Application No: EP/120/21/HH
Site Address: 9 The Ridings East Preston BN16 2TN
Description of works: Single storey rear extension and conversion of garage to habitable use

Thank you for your internet representation made on 12th November 2021 which has been recorded as an objection with the comments as follows:

Floor Plans and Elevations -  
Proposed

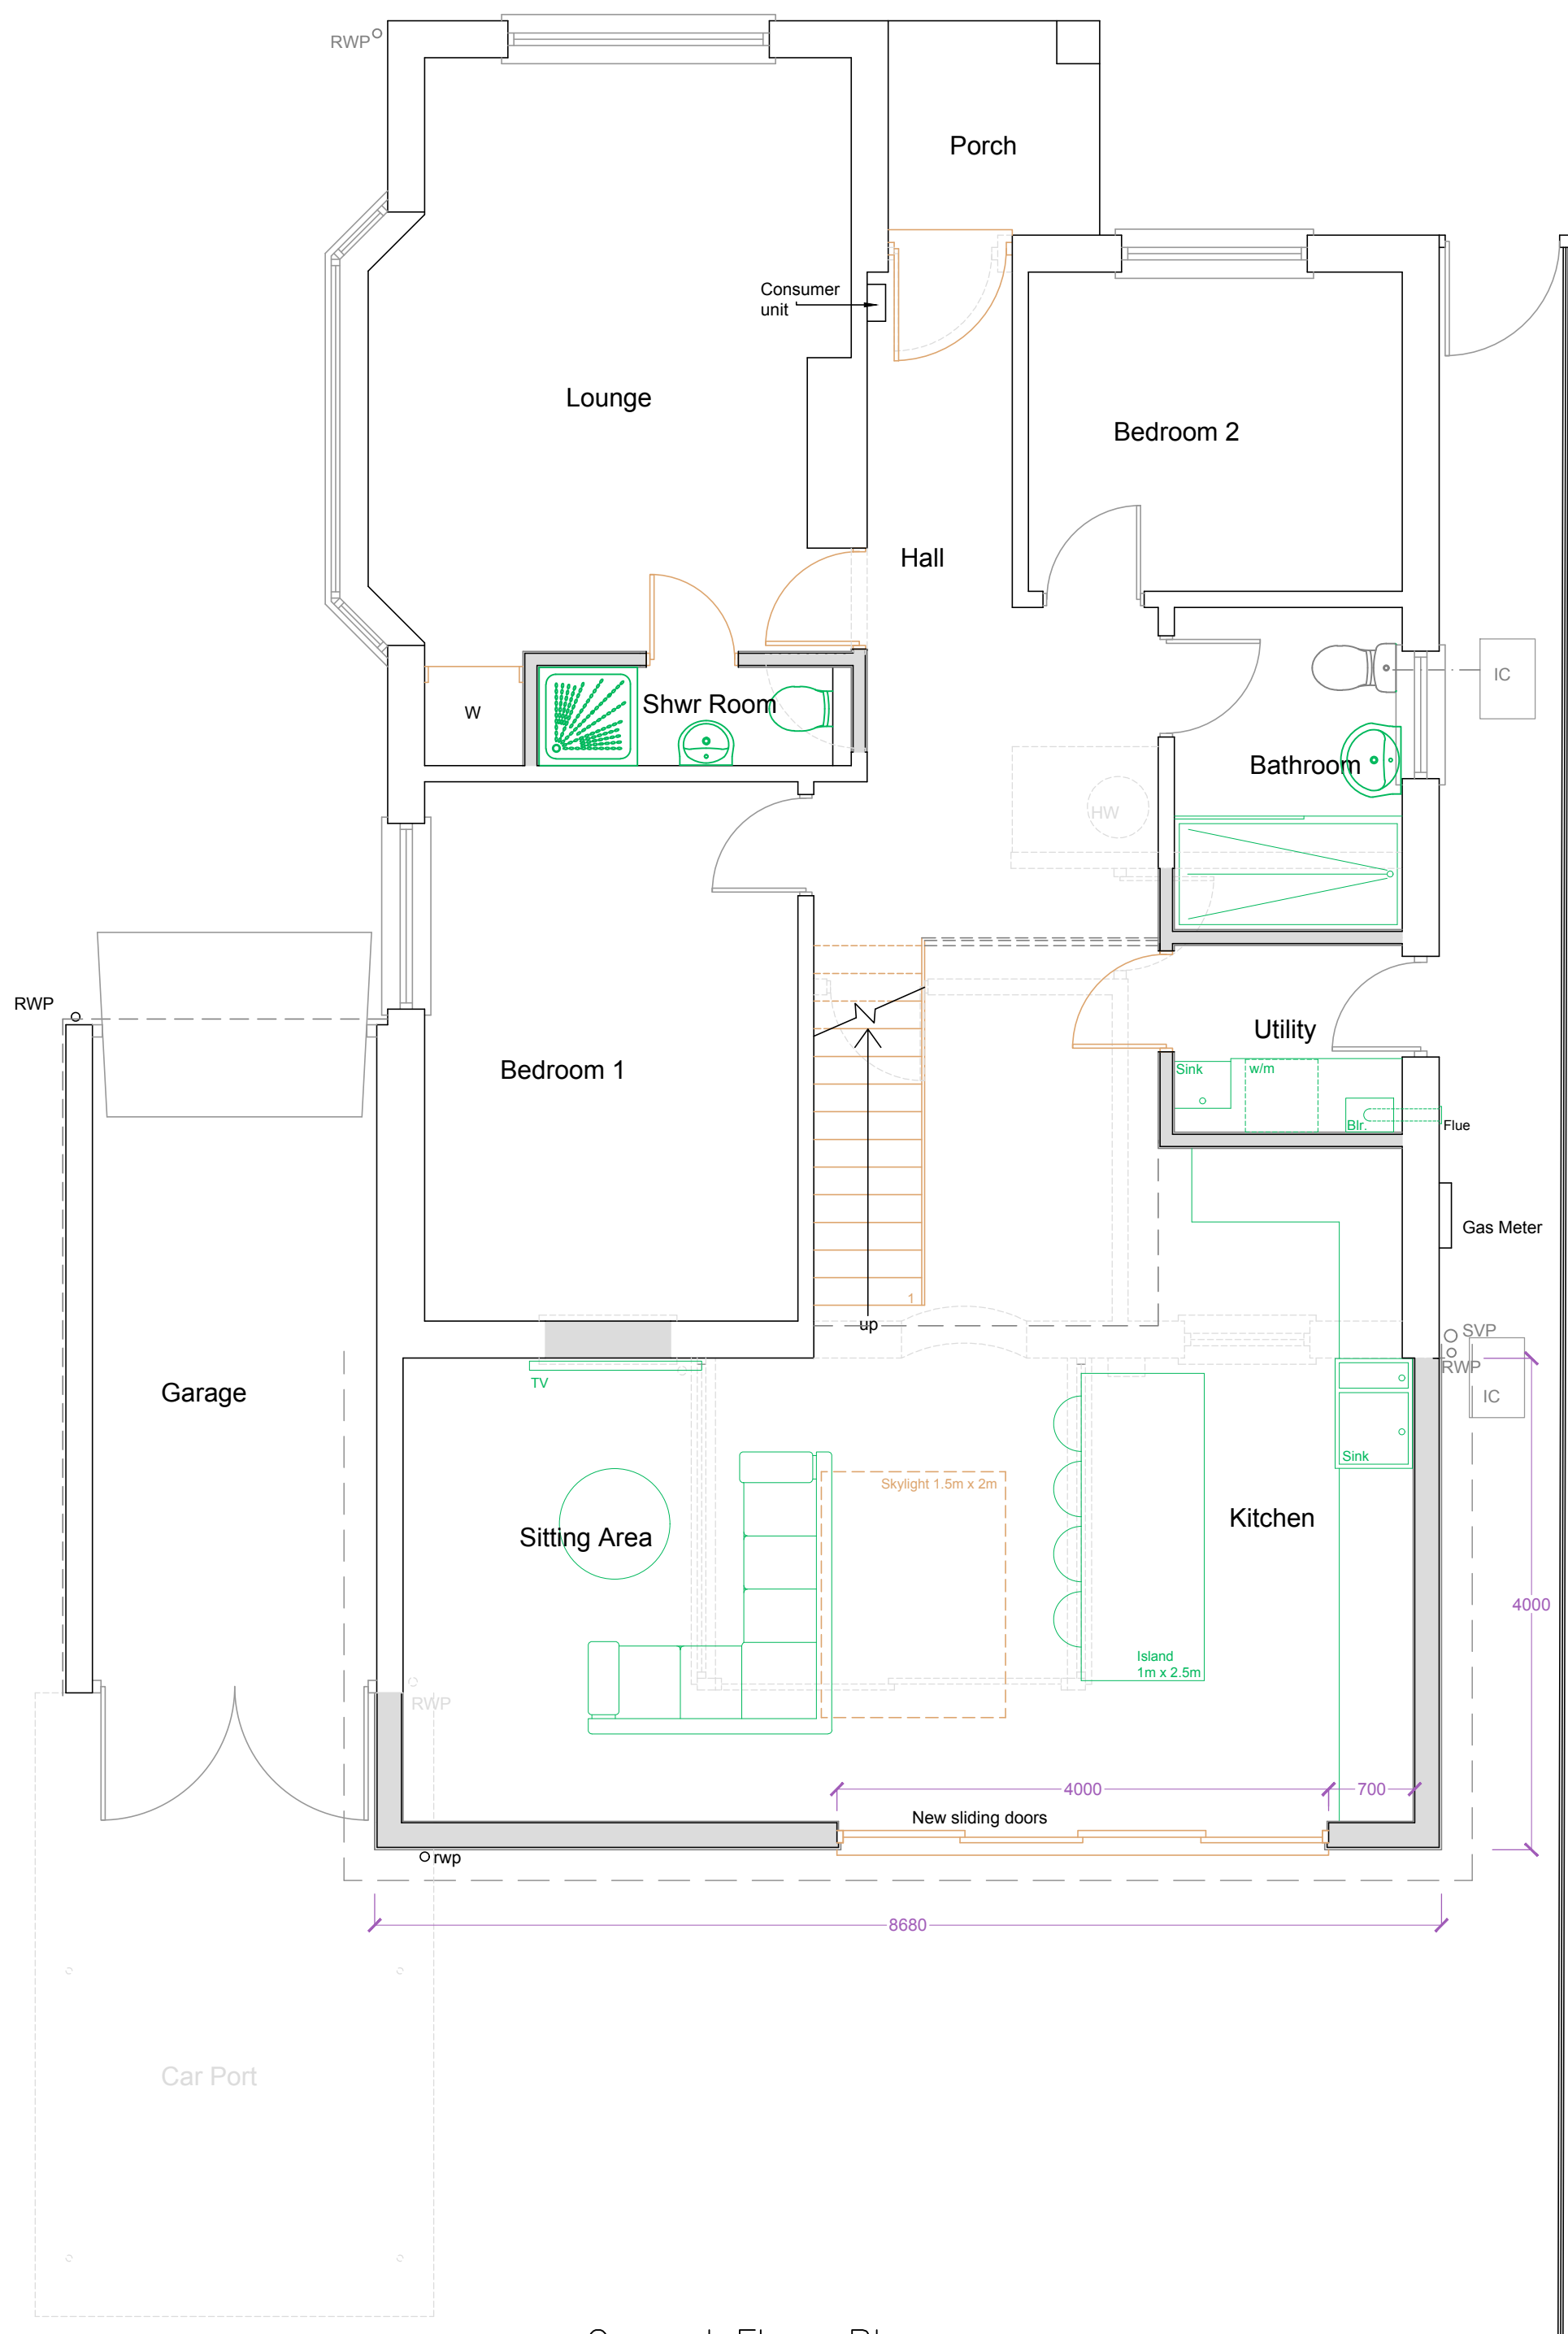
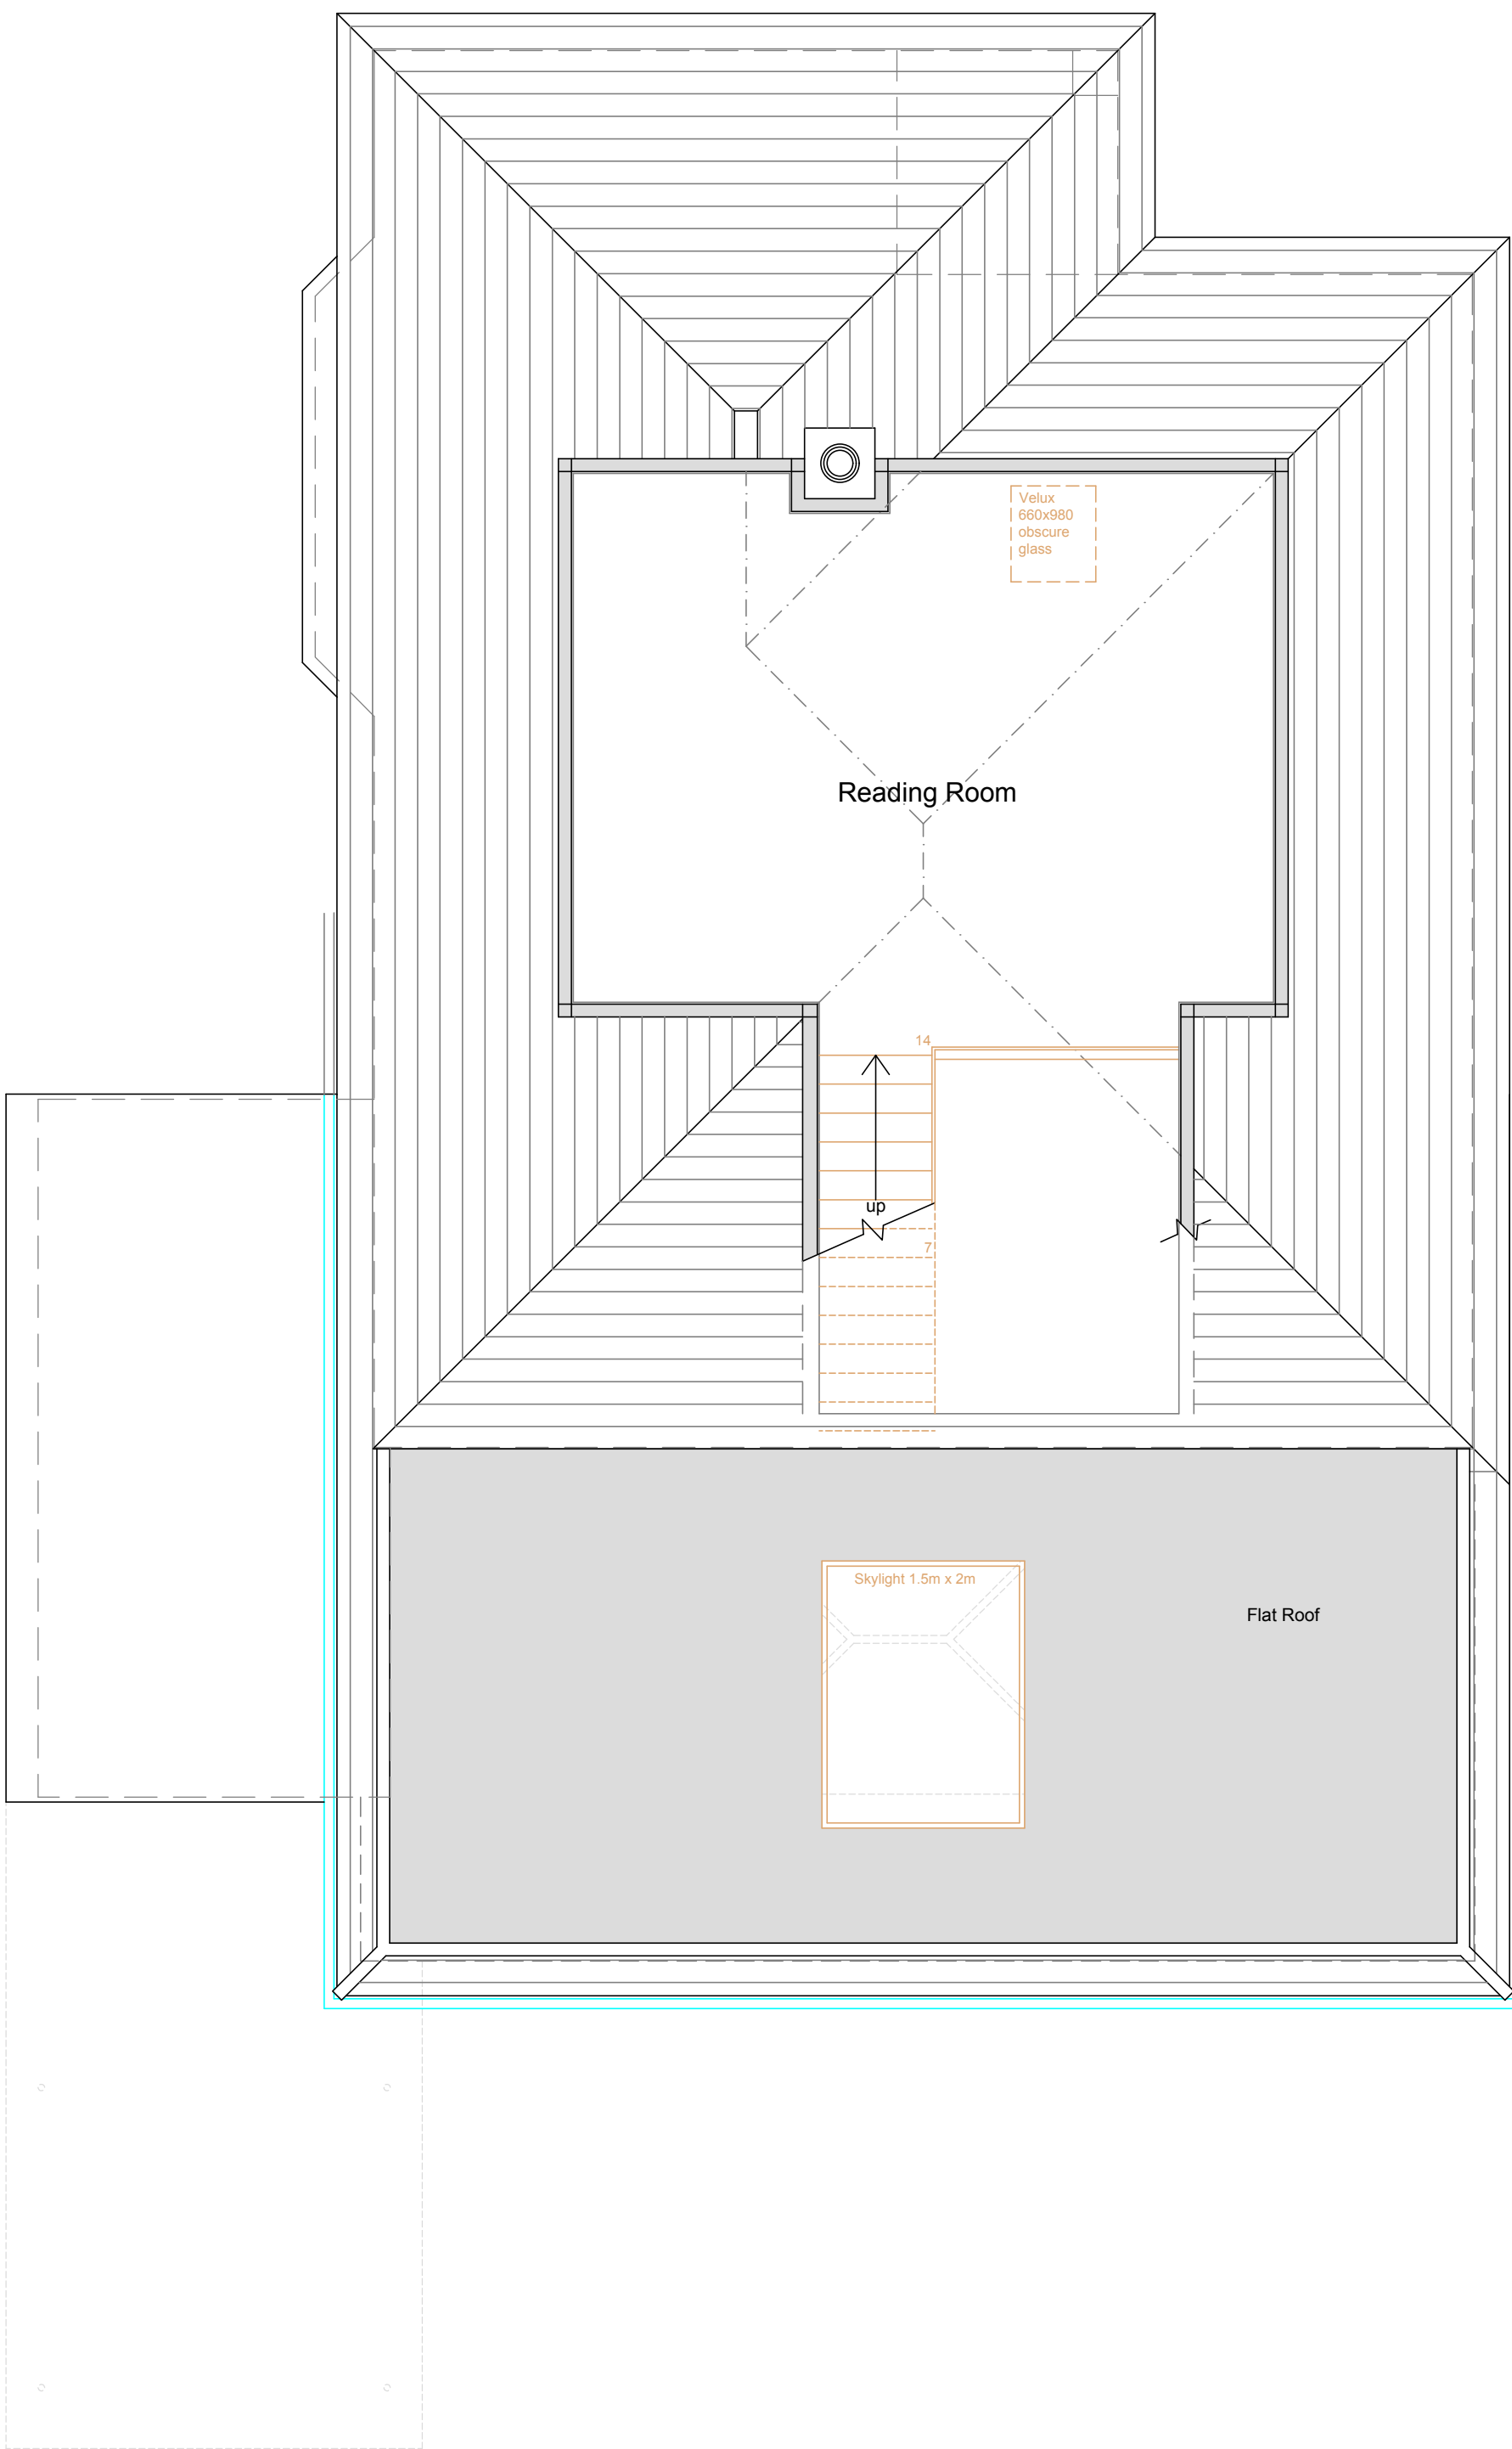
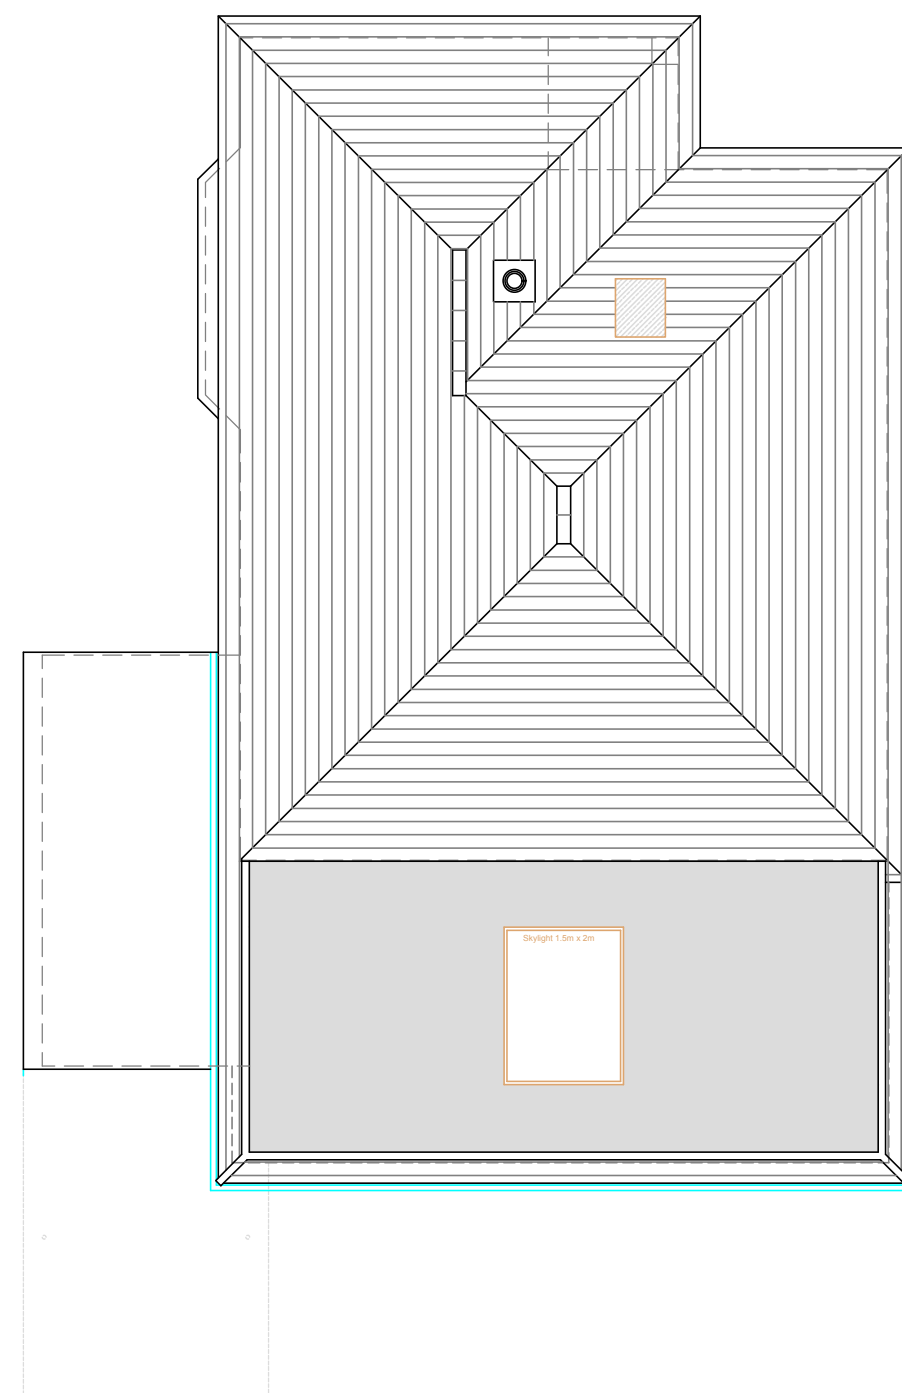
The committee agreed to object on the grounds it is unclear from the plans whether or not just the extension will be finished in white render or whether the plan is to finish the whole building in white render. If the latter, this would be an unacceptable change to the streetscene in that part of The Ridings. All other bungalows in that area are either wholly brick or half-brick, half-render. This particular property also has an attractively-detailed, brick pillar at the front of the property and the council hopes that will not be lost to a covering of render.

The council has no objections to the proposed extension but it would like to see the visual character of the property retained and kept in keeping with neighbouring bungalows.
